From: Judith Ward
Sent: 15 July 2021 14:13
To: Rebekah Morgan
Subject: 21/02177/DISC Graven Hill Development Company. Roundabout to GH and Wretchwick Green, Bicester

Judith Ward
Landscape Planning Officer
Cherwell District & South Northants Councils

Amendments  
**GRAVENHILL, BICESTER**  
**A41 ROUNDABOUT LANDSCAPE GA SHEET 1 OF 3**

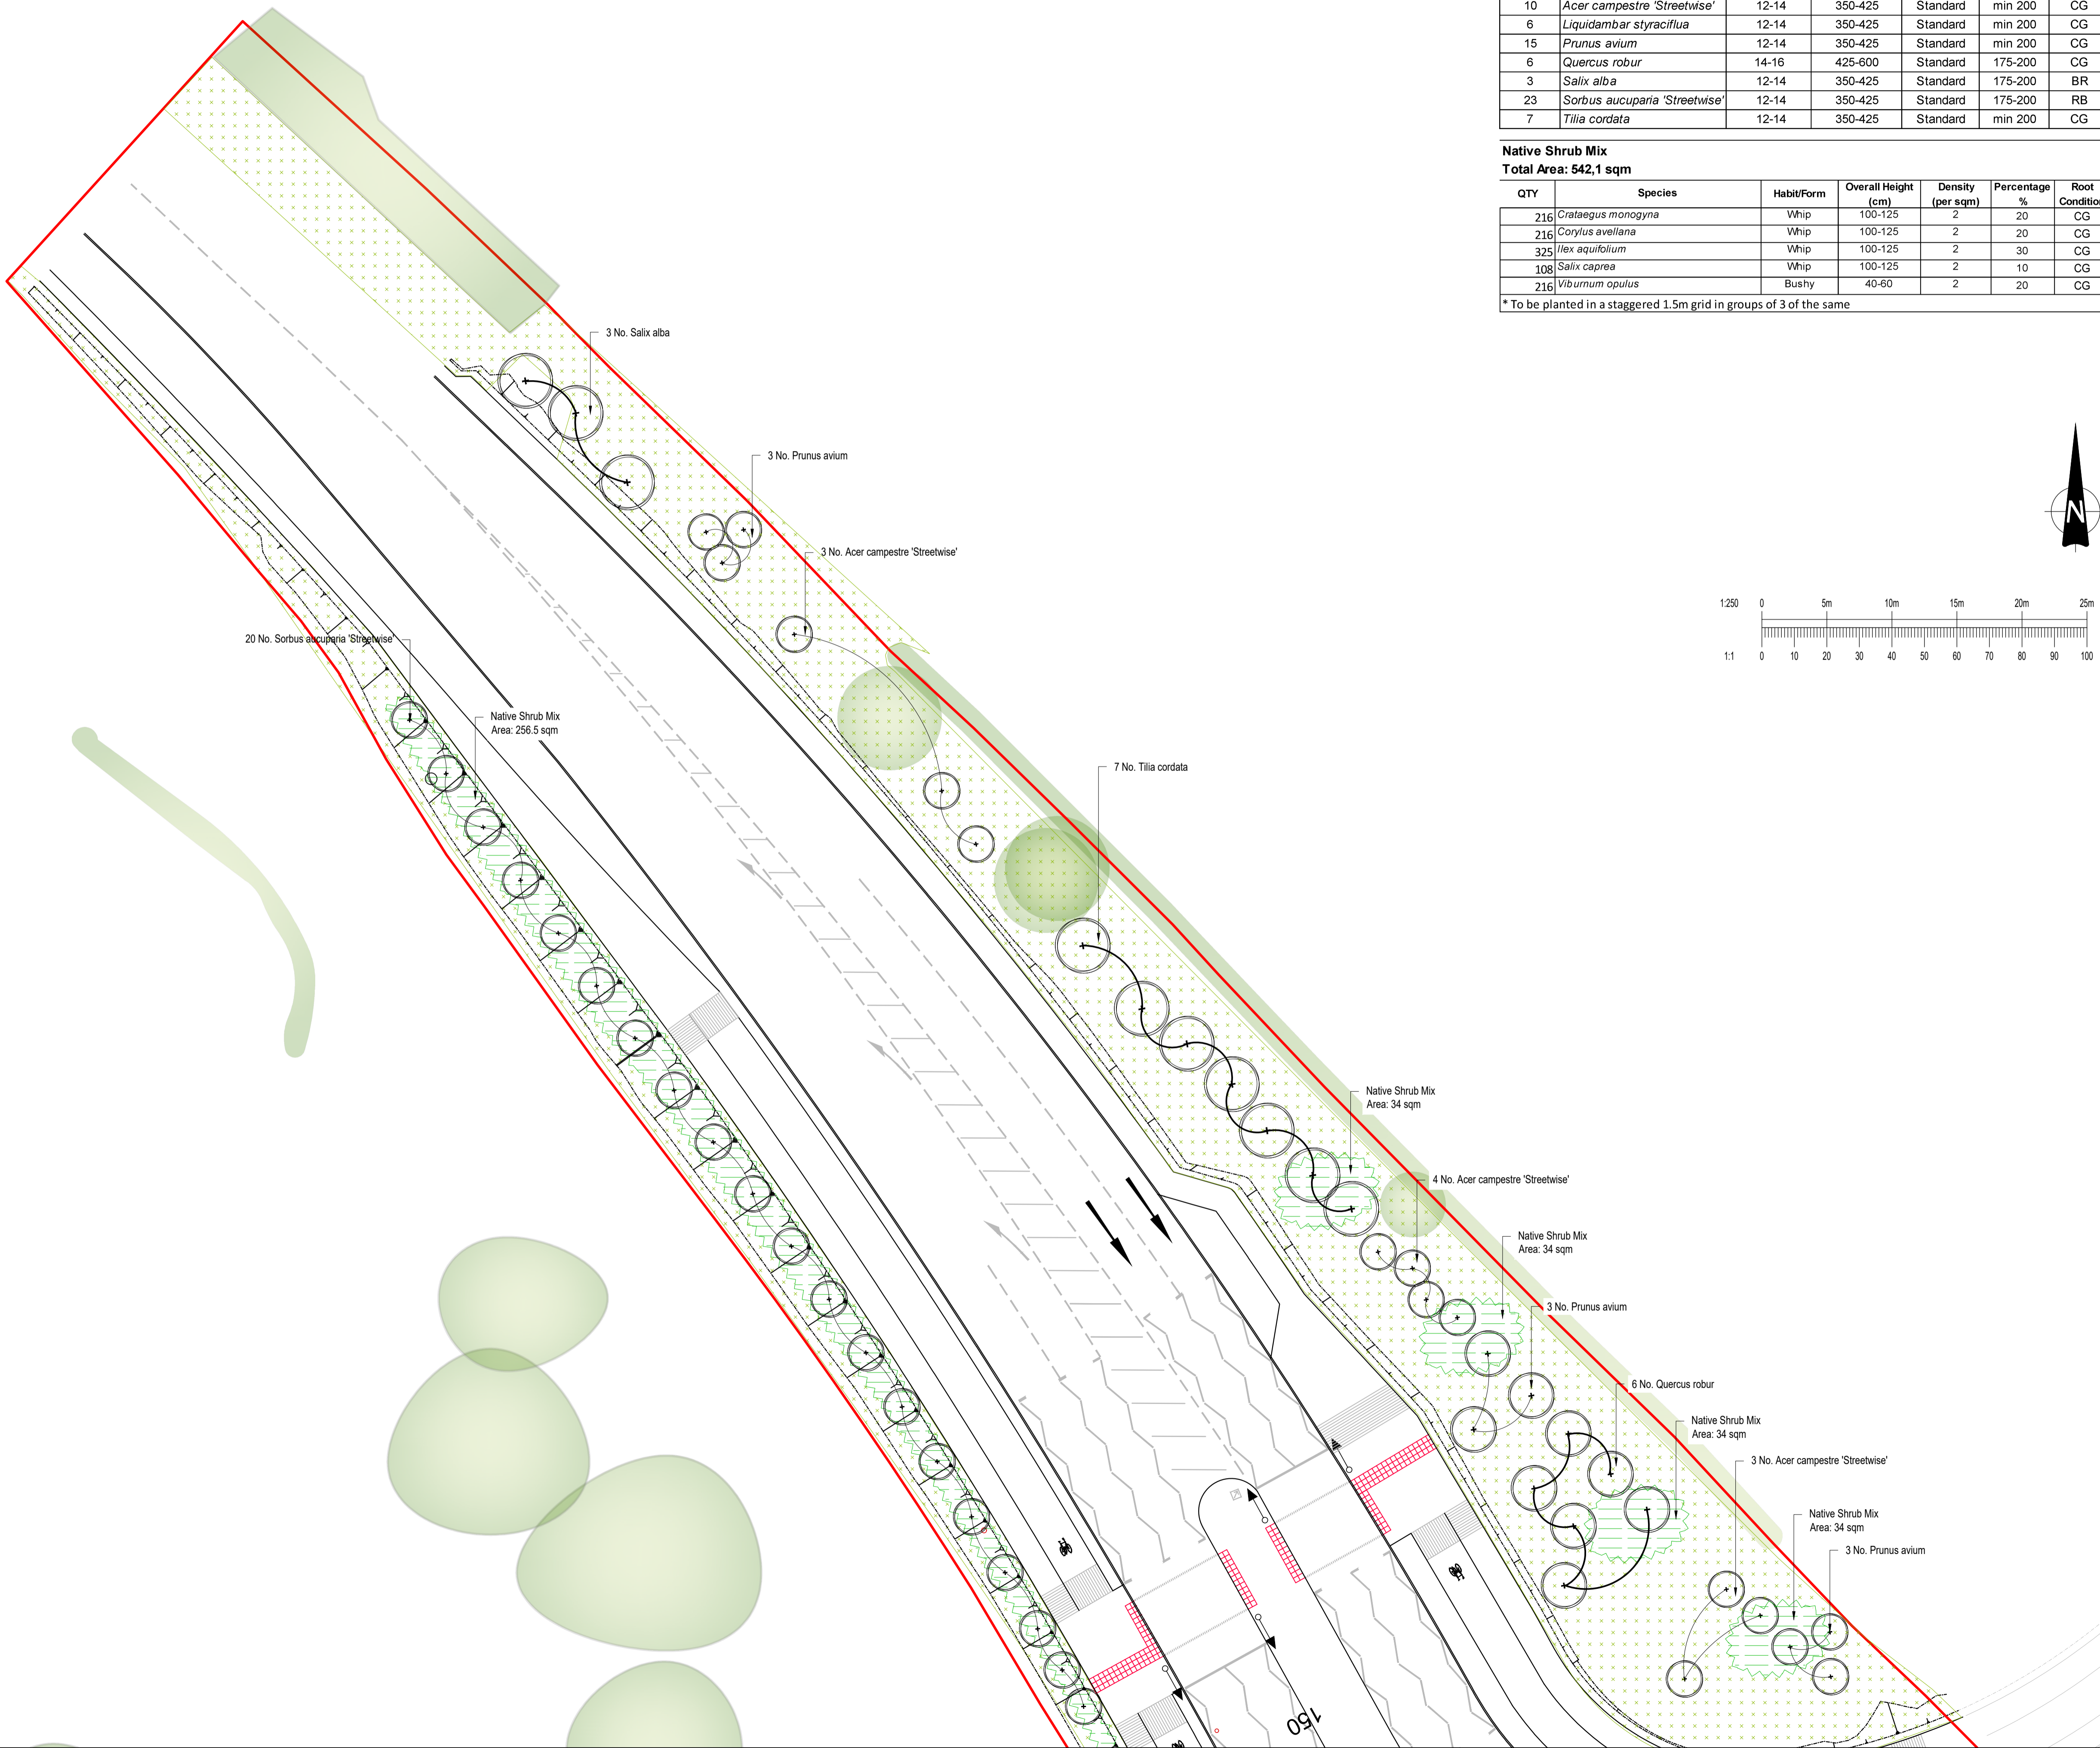
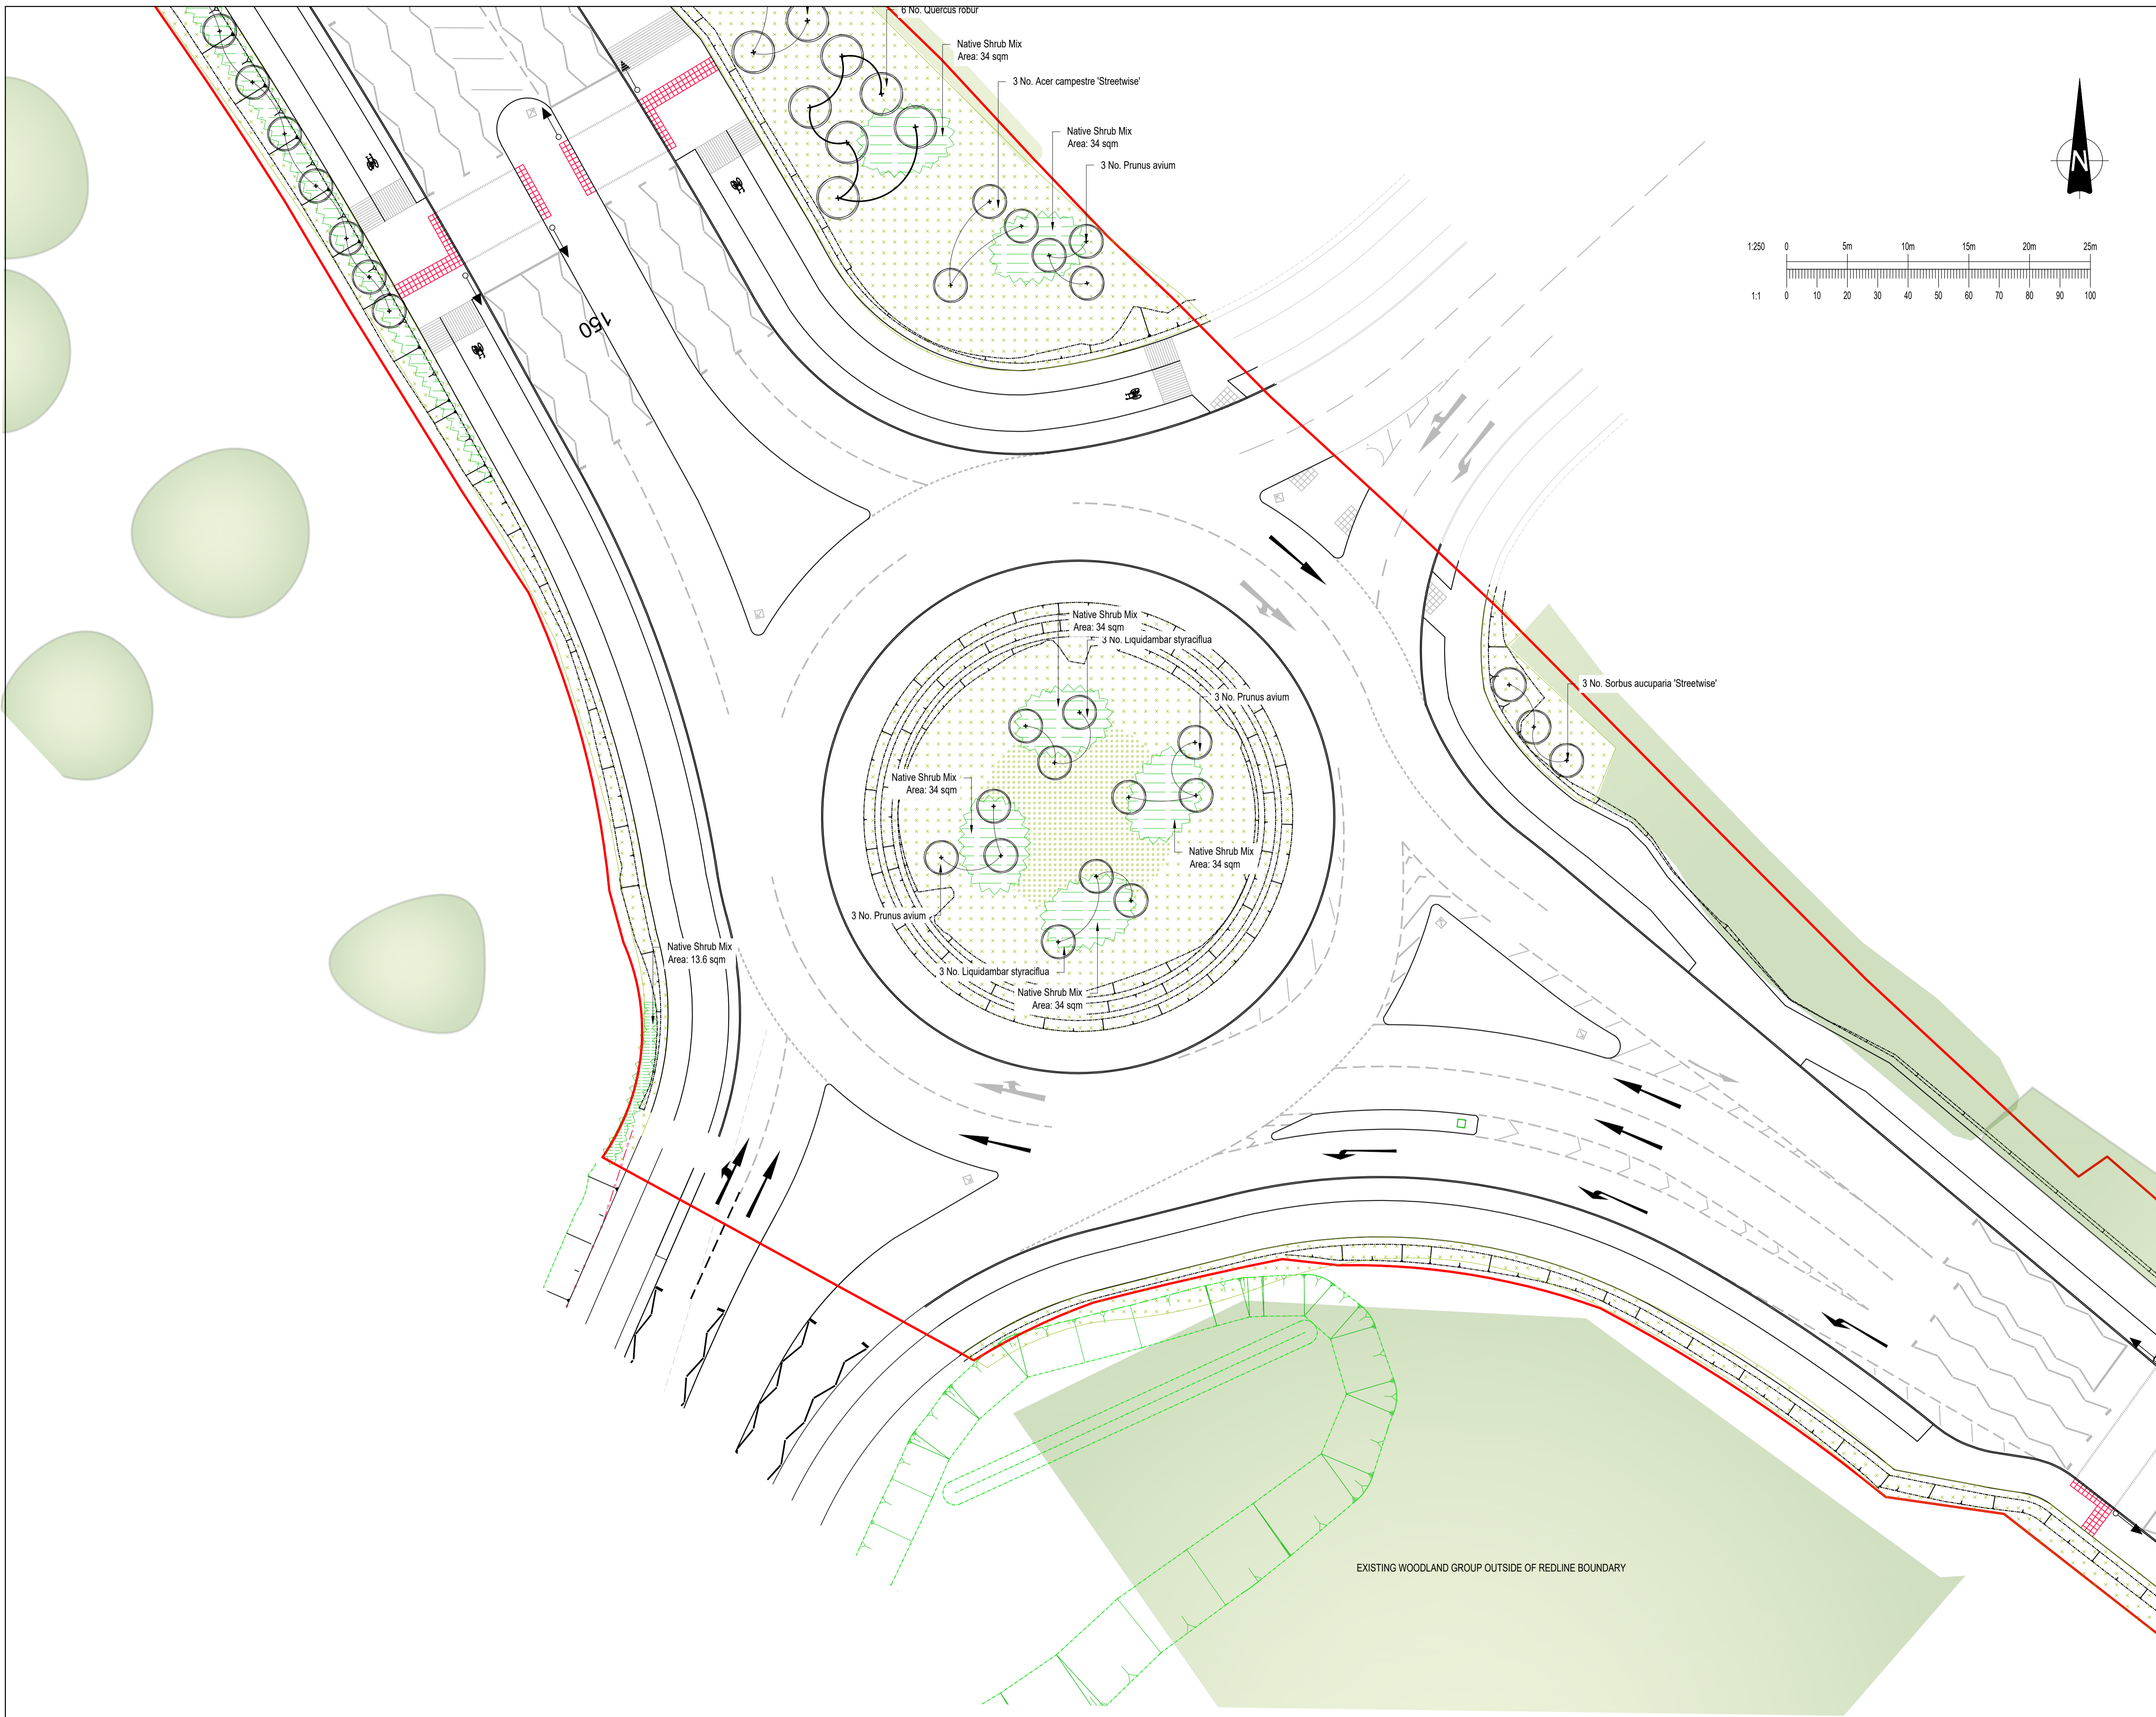
Prunus don't grow well on the heavy clay soil which we have at GH. An alternative tree should be specified.

Tree sizes are far too small for a key entry point to the site.

Cornflower annuals will need re-seeding every year so are unsuitable. We don't have the budget to do this. A wildflower seed mix with perennial wildflowers should be specified.
